Subject: RE: 3/2022/0537-Land Adjacent to Ferns Northcote Road Langho BB6 8BG

Please find attached revised drawings addressing the both yours and highways comments:-

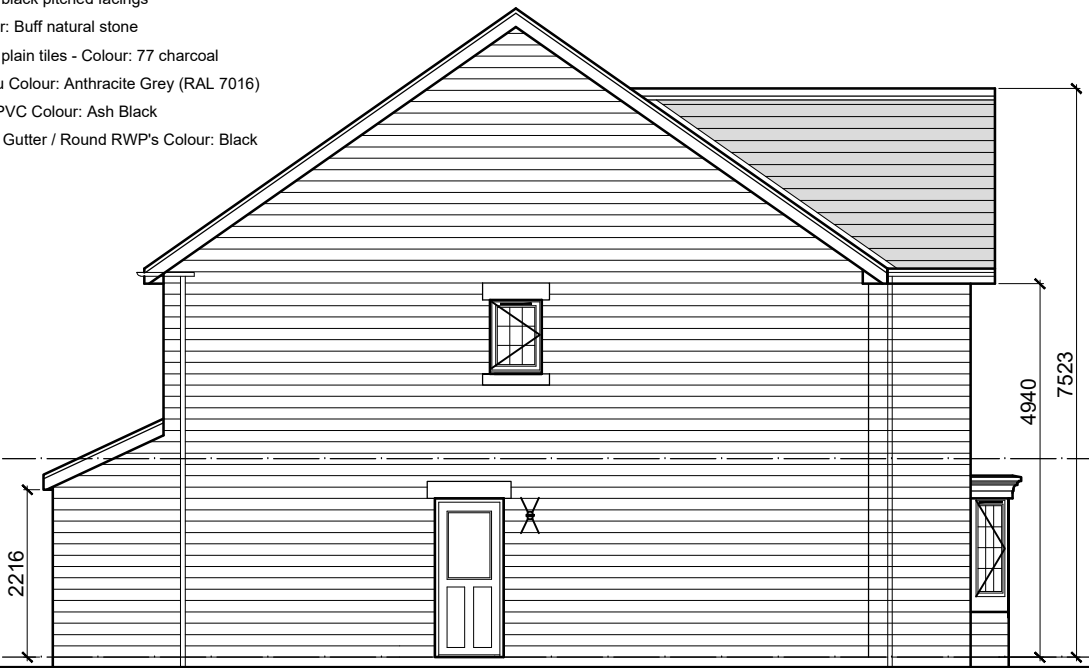
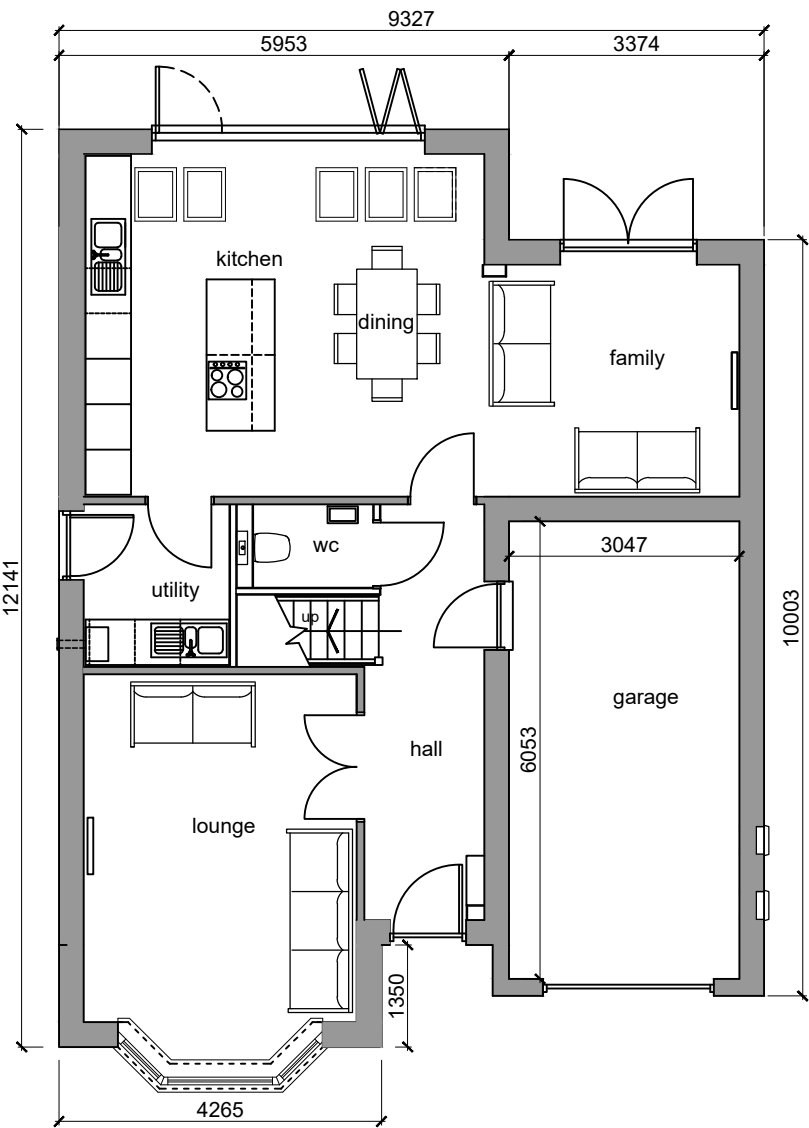
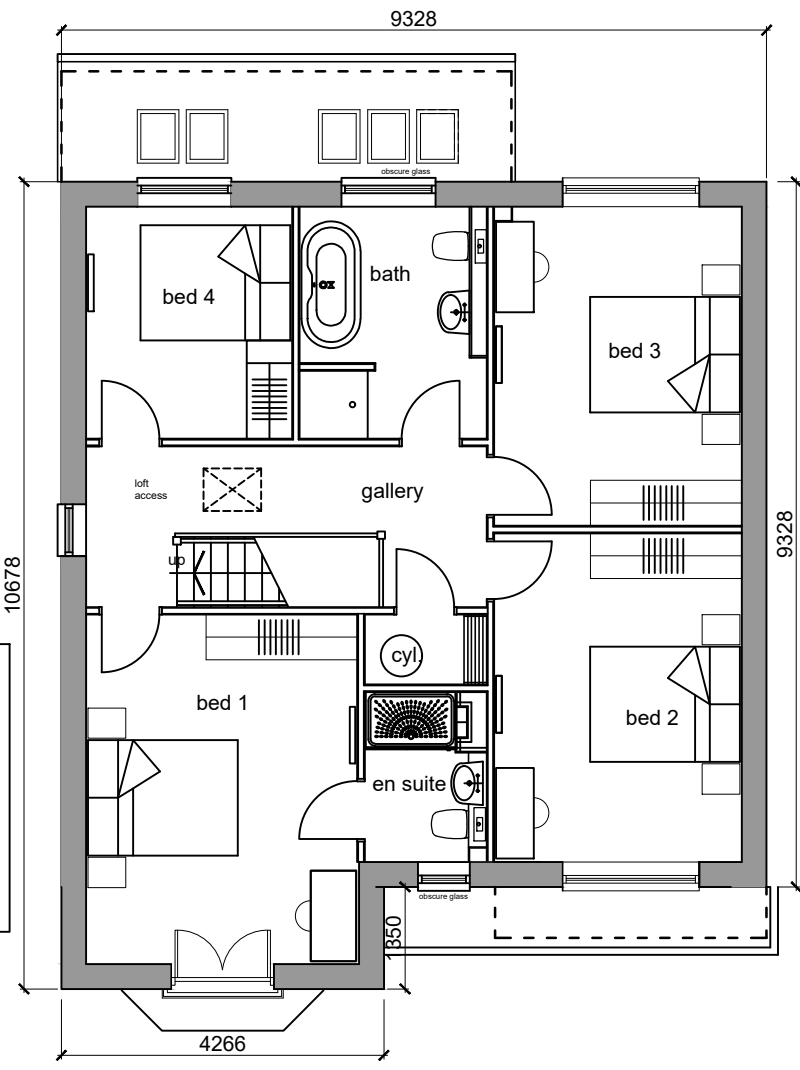
- White render can be quite stark in appearance and would give more prominence to the gables;
We can adjust the colour of the render to something more palatable like an ivory colour. We have attached photographs and images of previous developments to give an indication of the proposed materials to be used.

BOUNDARY FENCING AND WALLS

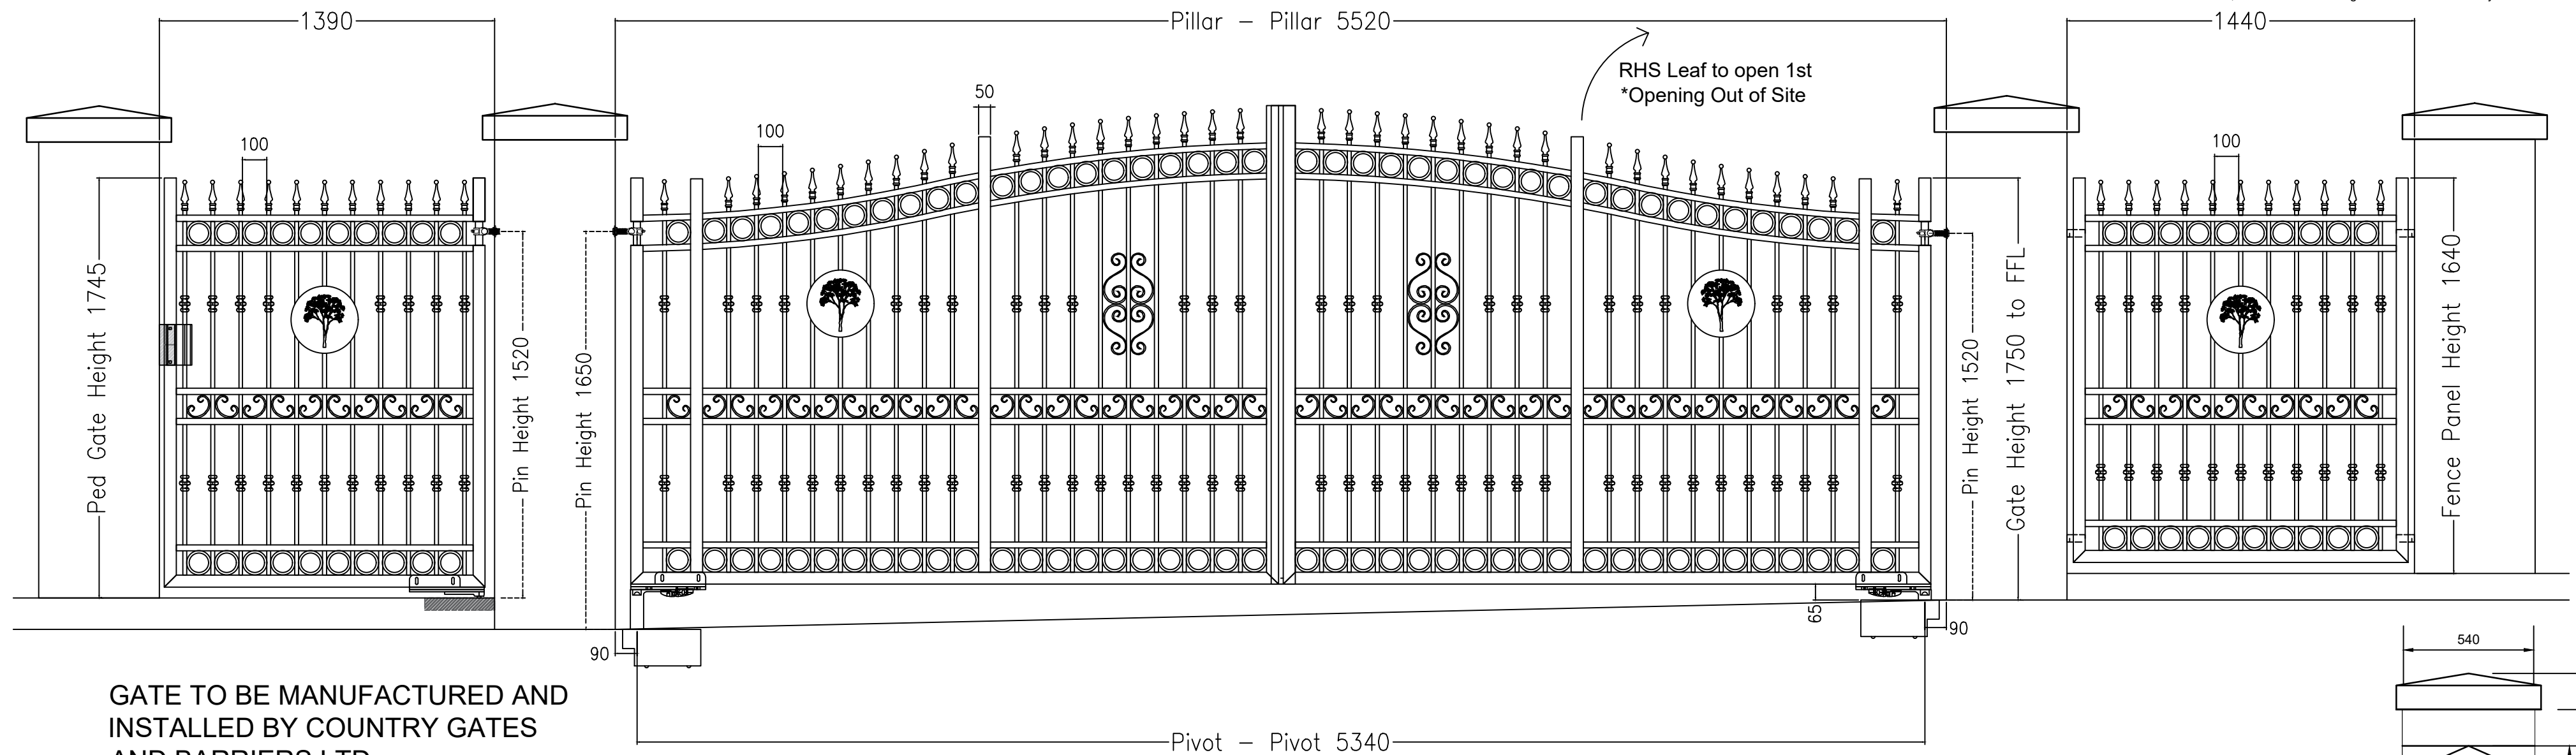
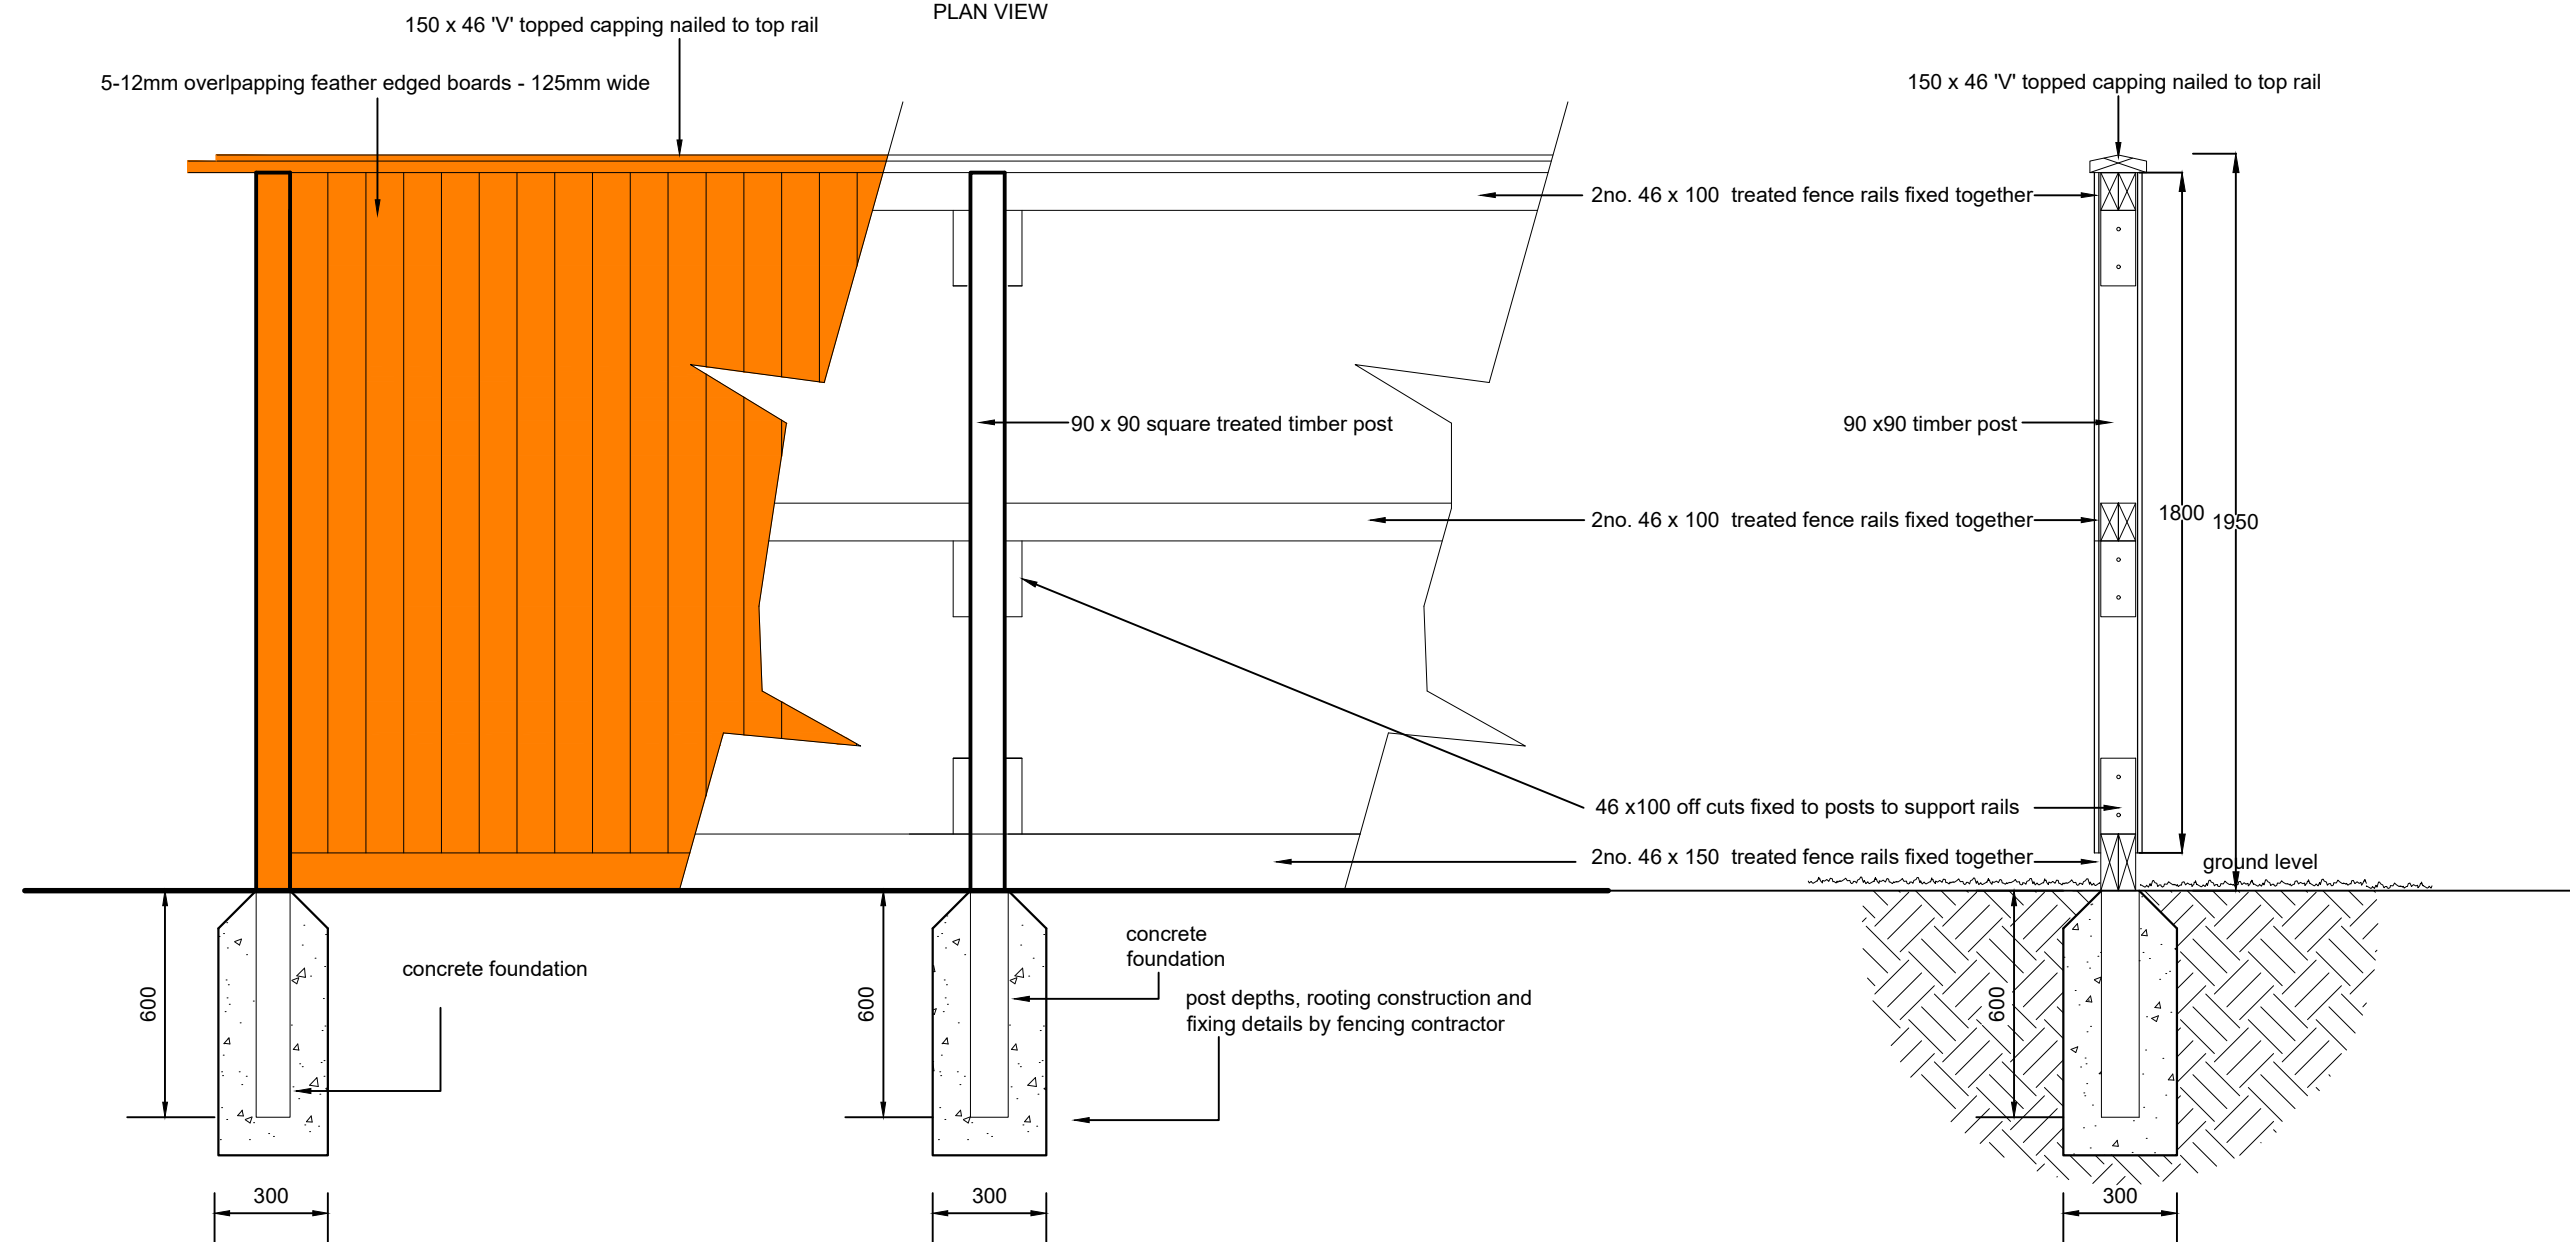
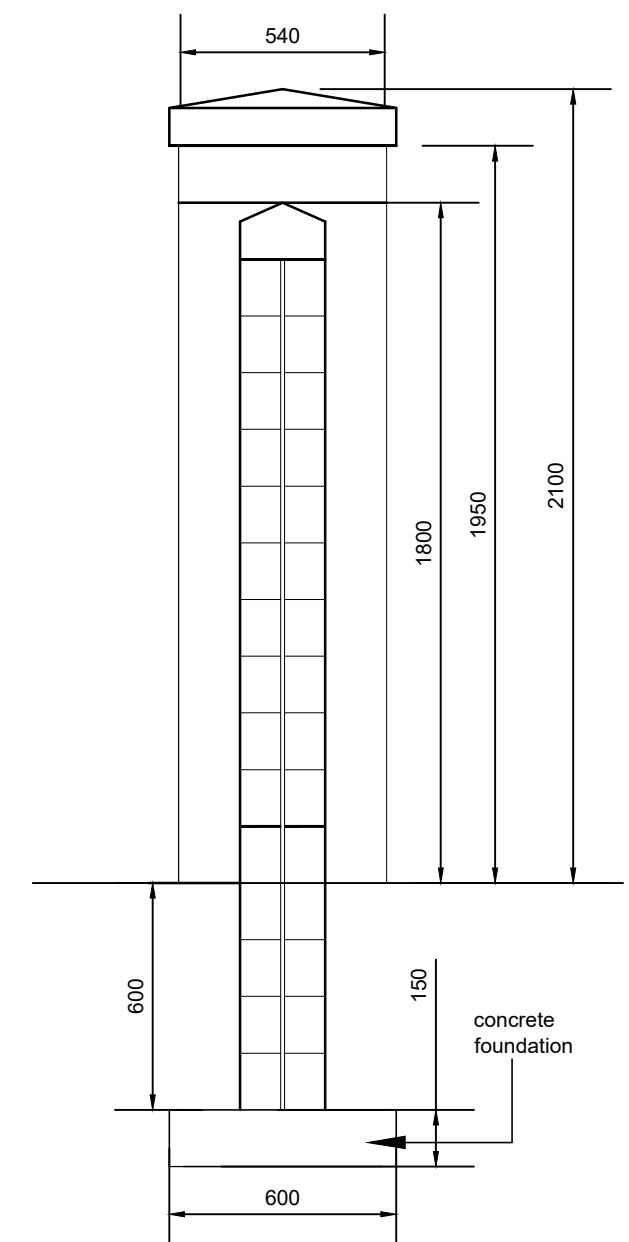
- A hedgerow with internal fencing similar to that on Northcote Road would be more appropriate boundary onto Whalley Road and would soften the scheme;
We agree with your comment and have set the fencing line back from the boundary of plots 1 and 2 to allow for a new hedgerow to be planted to soften the scheme appearance from the road. Beyond plot 2 there is a significant amount of mature trees and shrubbery (see photo existing boundary to Whalley Road)
